Harnett County Government Complex  
307 Cornelius Harnett Boulevard  
Lillington, NC 27546

Re: Status of Improvement Permit Application #05-5-12583

On July 14, 2005, an Environmental Health Specialist from the Harnett County Health Department attempted to evaluate your property for the purpose of issuing an Improvement Permit. This individual was unable to evaluate your property for one or more of the following reasons.

SITE PLAN APPROVAL
 DISTRICT R200 USE sumit
 #BEDROOMS 2
7-1105
 ZONING ADMINISTRATOR

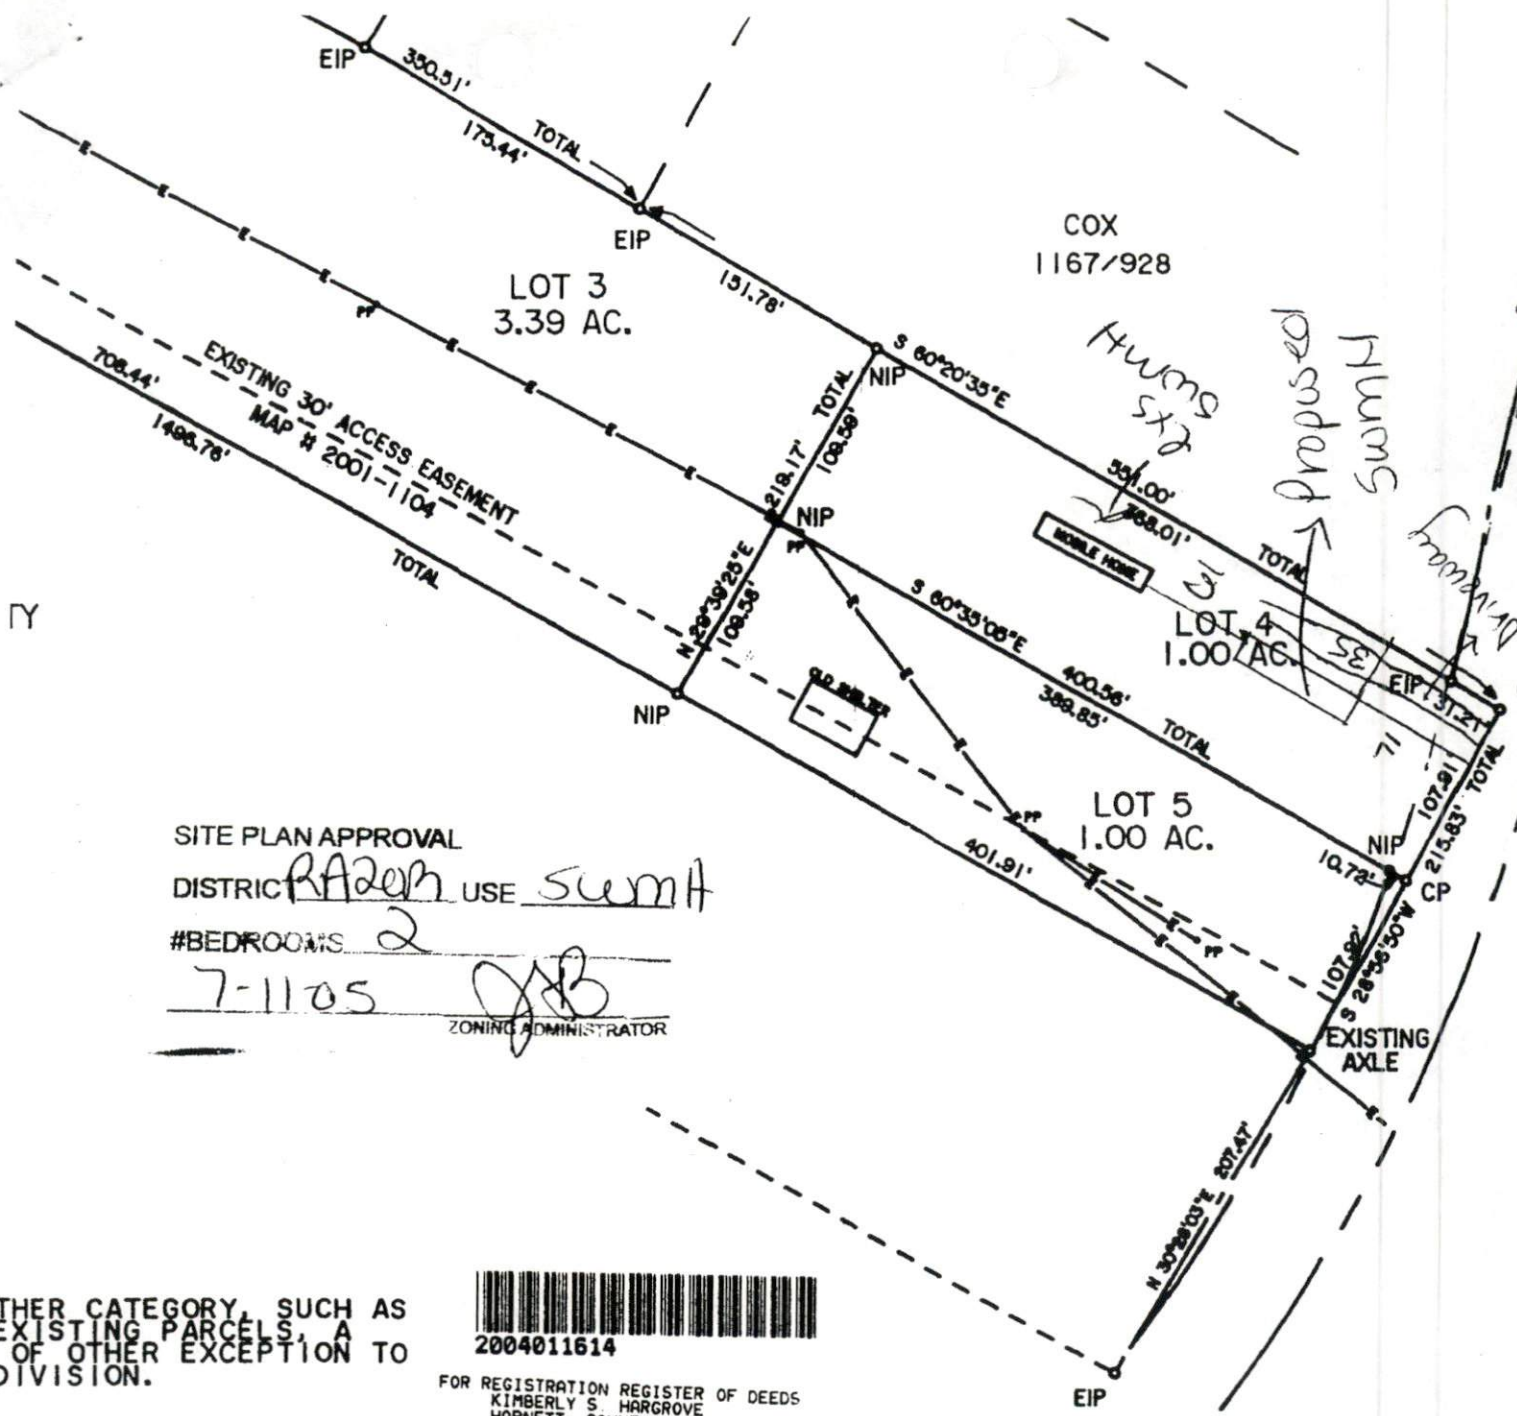
- 1. Property lines/corners not marked or labeled
- 2. House corners not marked or labeled
- 3. Directions not clear to property
- 4. Property needs brush or vegetation removed
- 5. Backhoe pits required
- 6. Other **Change house location as shown, and resubmit to Central Permitting. You will need to reconfirm through the IVR system also, when site is ready.**
